**Consultation Response from KC,
Trees**

2025/90352 adj, 33a, Church Lane, Clayton West, Huddersfield, HD8 9LY

Discharge of details reserved by conditions 6 (boundary treatments), 8 (intrusive site investigations and remedial works), 9 (declaration), 10 (Phase I Desk study Report), 11 (Phase II Intrusive Site Investigation Report), 12 (Remediation Strategy), 13 (Remediation Strategy), 14 (Verification Report) and 15 (Arboricultural Method Statement and Tree Protection Plan) of previous permission 2024/93464 for variation condition 2 (plans) on previous permission 2023/91483 for demolition of garage and erection of detached dwelling.

Date Responded: 27/03/2025

Appendix 2 Tree Protection Plan

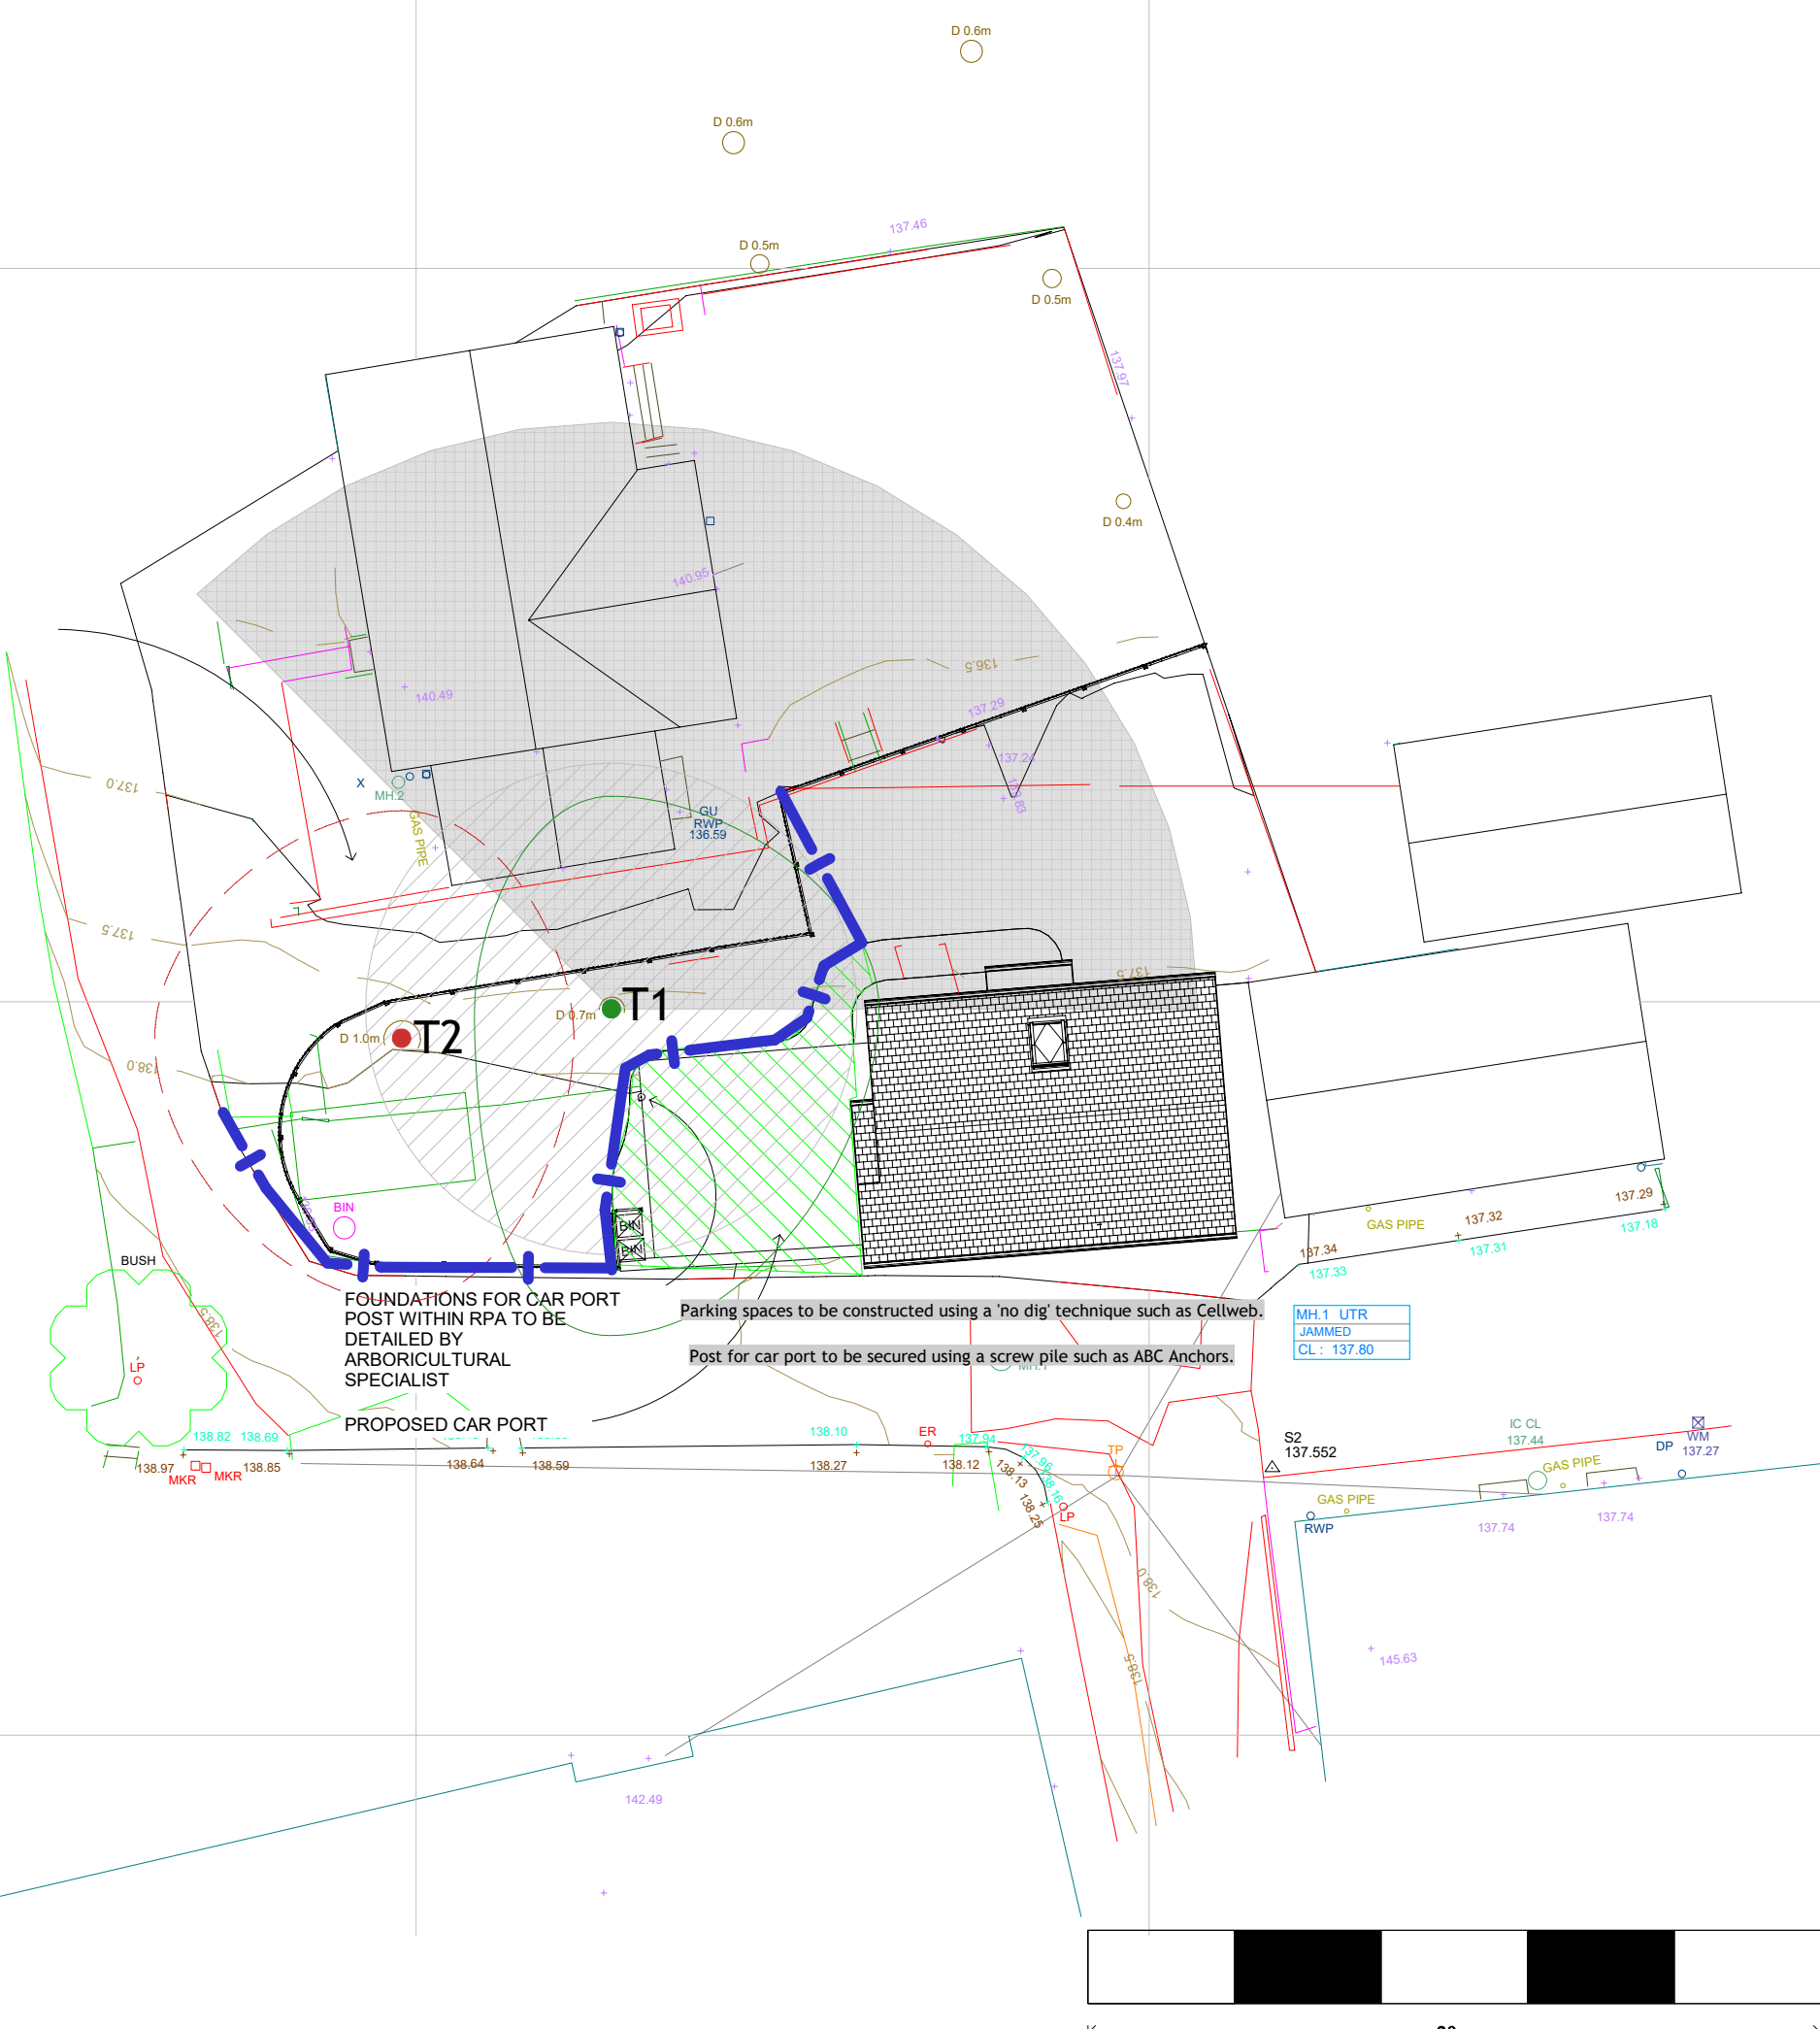
An amended Arboricultural Method Statement and tree protection plan have not been submitted to satisfy condition 15. **Therefore, Condition 15 cannot be discharged at this time.**

No development shall commence until a detailed Arboricultural Method Statement and Tree Protection Plan have been submitted to, and approved in writing by, the Local Planning Authority. The method statement shall include details of foundation design and how the construction work will be undertaken with minimal damage to the adjacent protected trees and their roots.
